Appeal Decision

Appeal Ref: APP/T2350/W/14/3001556

The Moorcock Inn, Slaidburn Road, Waddington, Clitheroe, Lancashire BB7 3AA

- The appeal is made under section 78 of the Town and Country Planning Act 1990 against a refusal to grant planning permission.
 - The appeal is made by Messrs S & A Thornber against the decision of Ribble Valley Borough Council.
 - The application Ref 3/2014/0592, dated 26 June 2014, was refused by notice dated 17 October 2014.
 - The development proposed is the demolition of the Moorcock Inn and the erection of 7 No. dwelling houses including associated drives, gardens and external landscaping works.
-

Drawing Title PROPOSED ROOF PLAN		
Scale 1:200 @ A1	Date JUNE 2014	Drawn TB

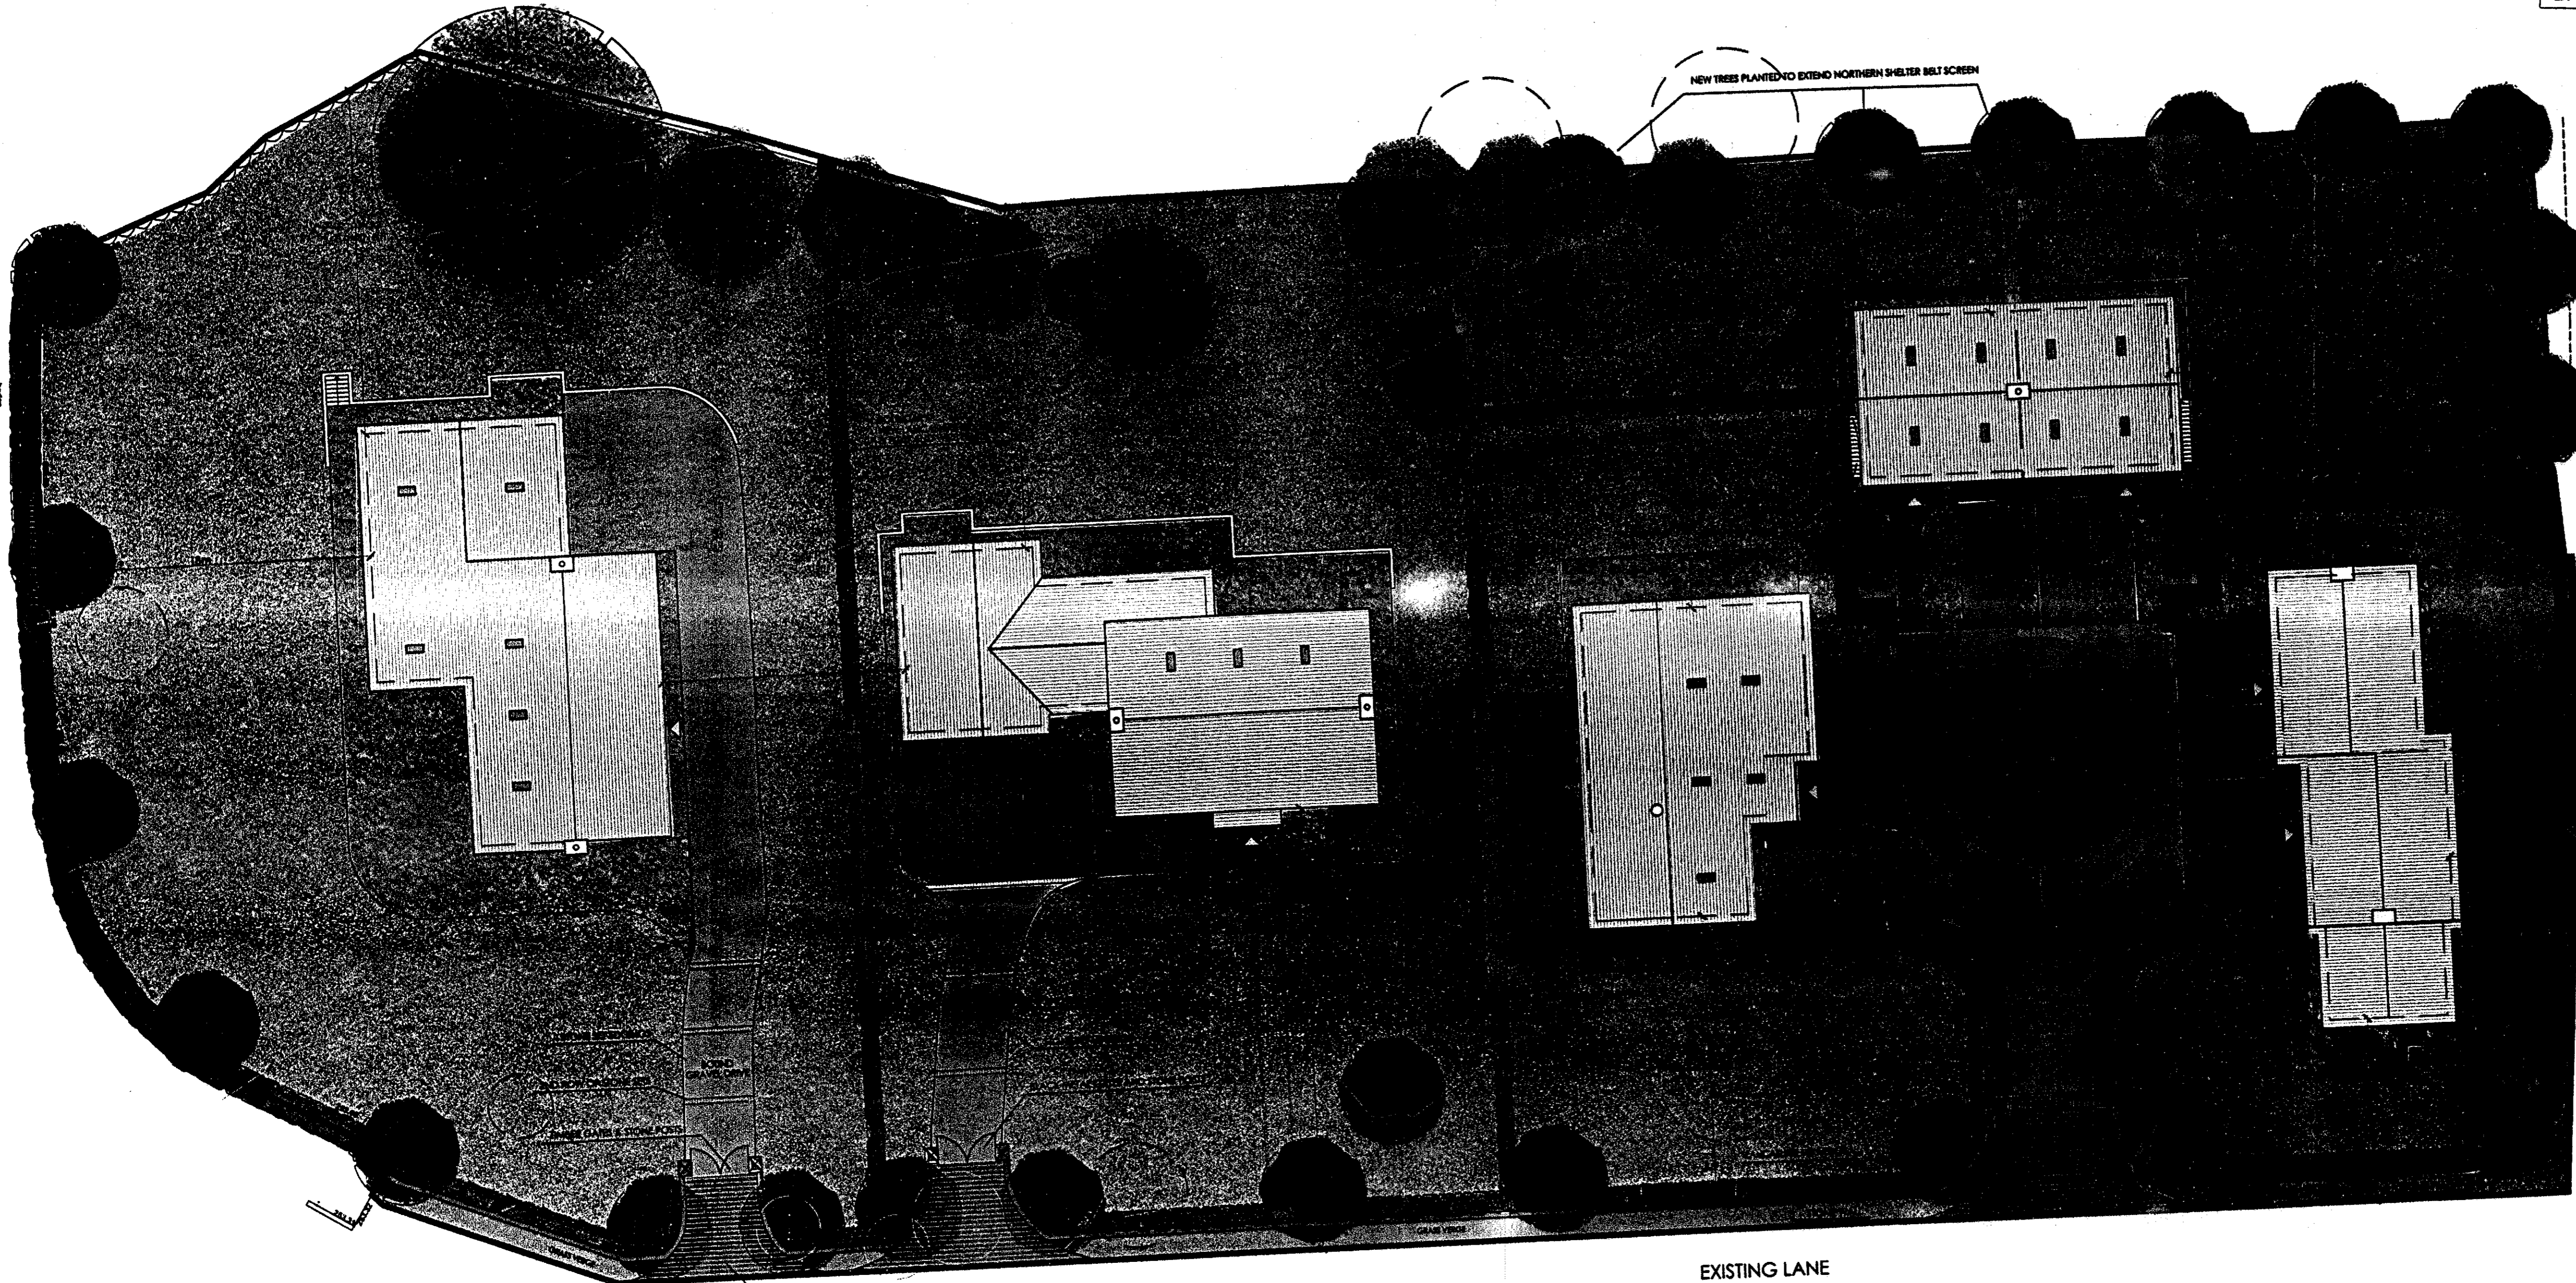
9. I accept that the proposal would use materials and design features that are more sympathetic to the vernacular architecture of the local area. In this respect, I acknowledge that the development would lead to some visual improvement. However, I note from the plans that plots 1-3 would extend beyond the footprint of the existing building and that the number of dwellings is such that a small hamlet would, in fact, be created. This would outweigh the above benefits because of the increased extent of the built form on the site and the additional visual impacts arising from the inevitable domestication of the associated curtilages.

Drawing Title
PROPOSED STREET SCENE ELEVATIONS

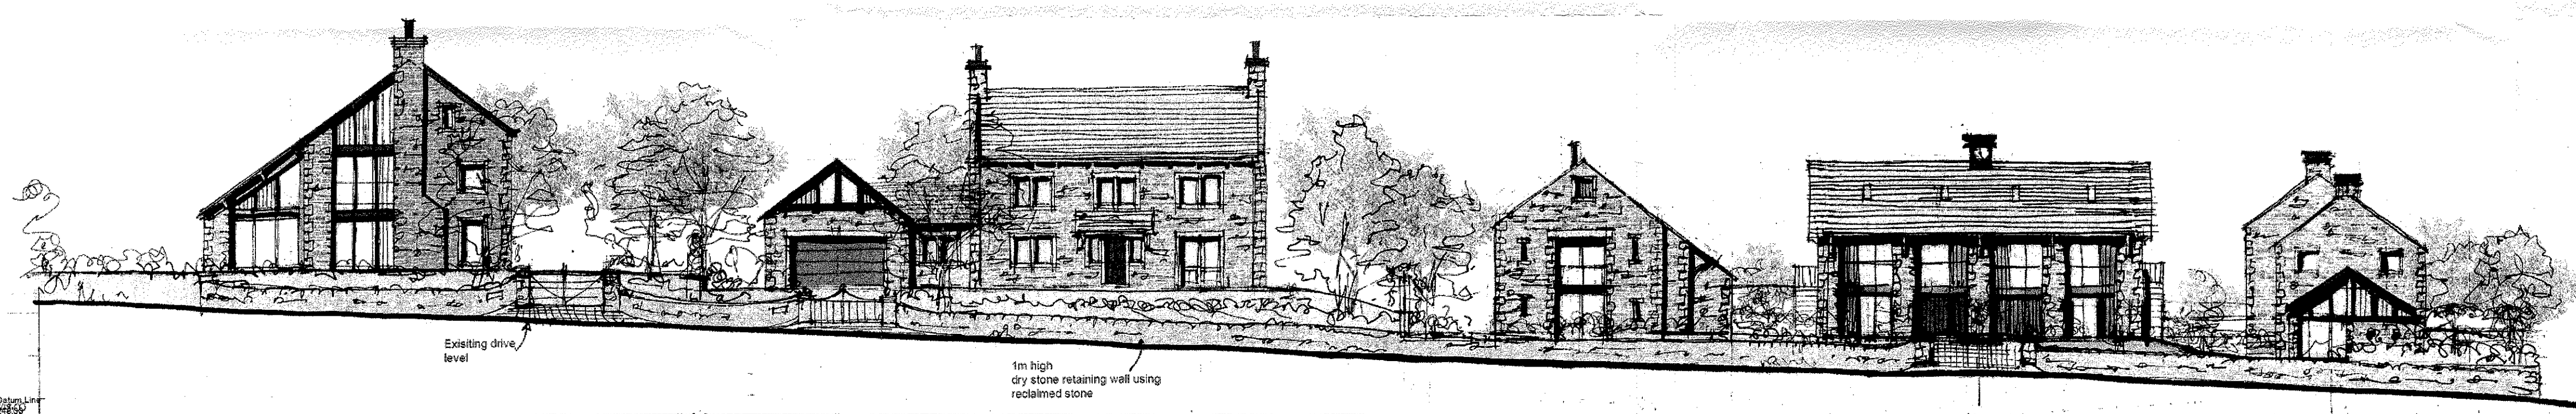
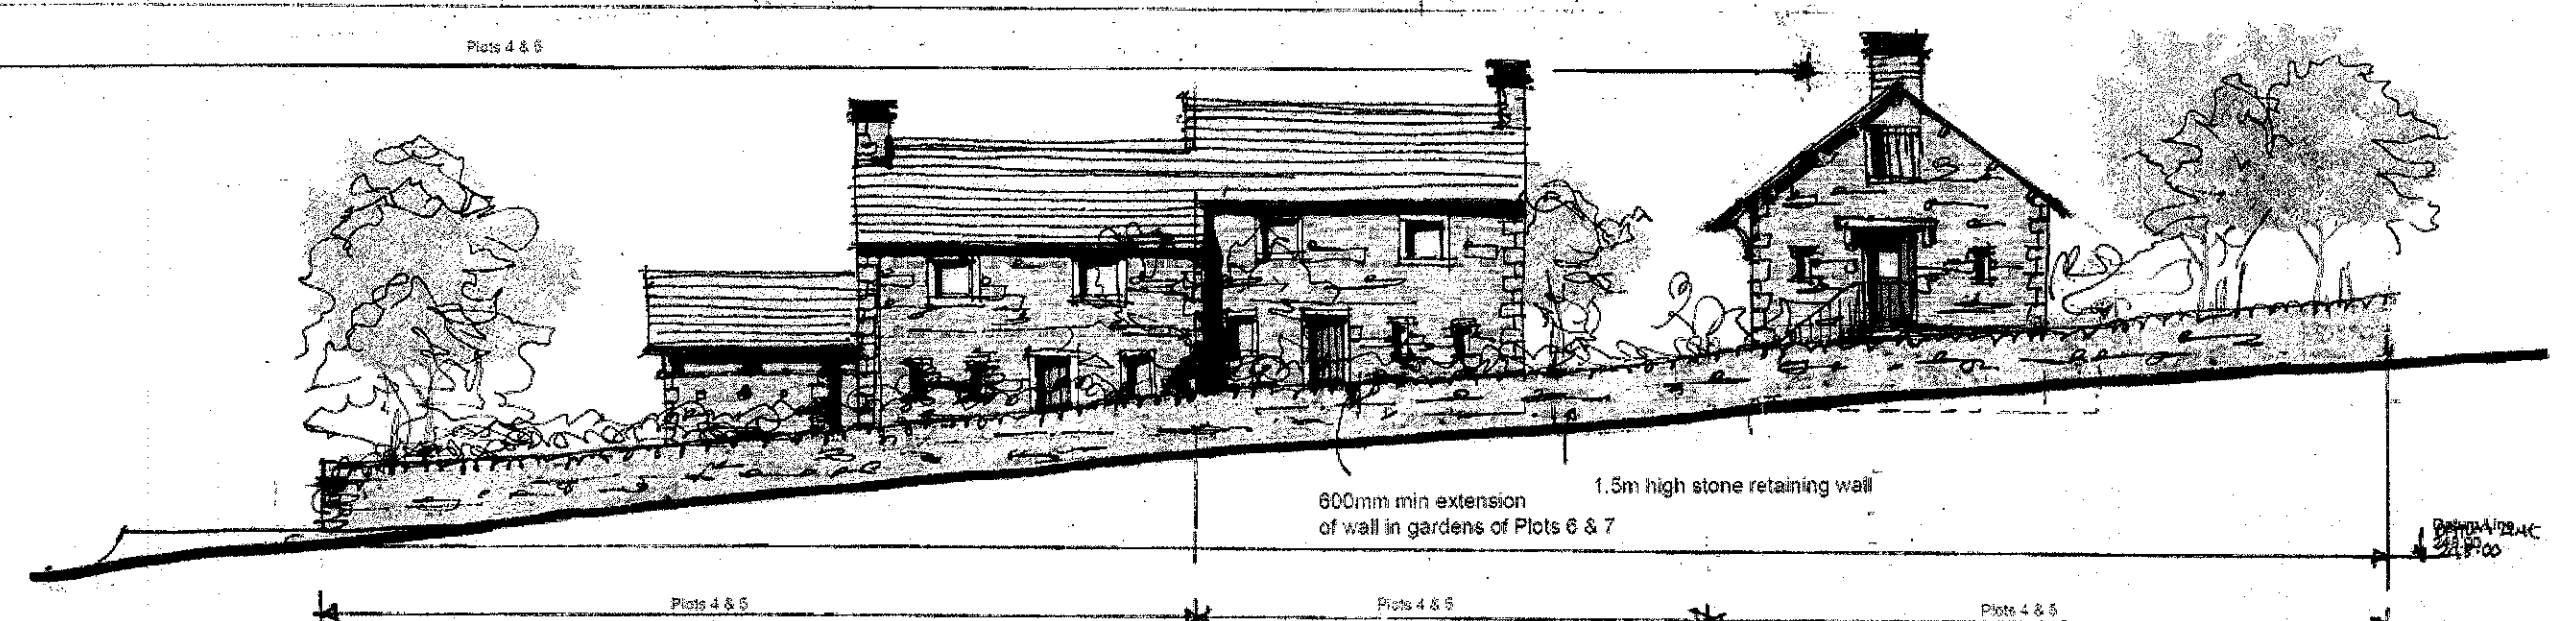
10. The appellants have suggested that the impact of the development on the surrounding landscape could be mitigated through the use of a sensitive landscaping scheme. However, this would be an impermanent solution in the absence of a planning obligation and would not, in any event, mitigate the views of the site from the surrounding fells. The development would lead to a significant erosion of the remoteness of the location and lead to an unjustified
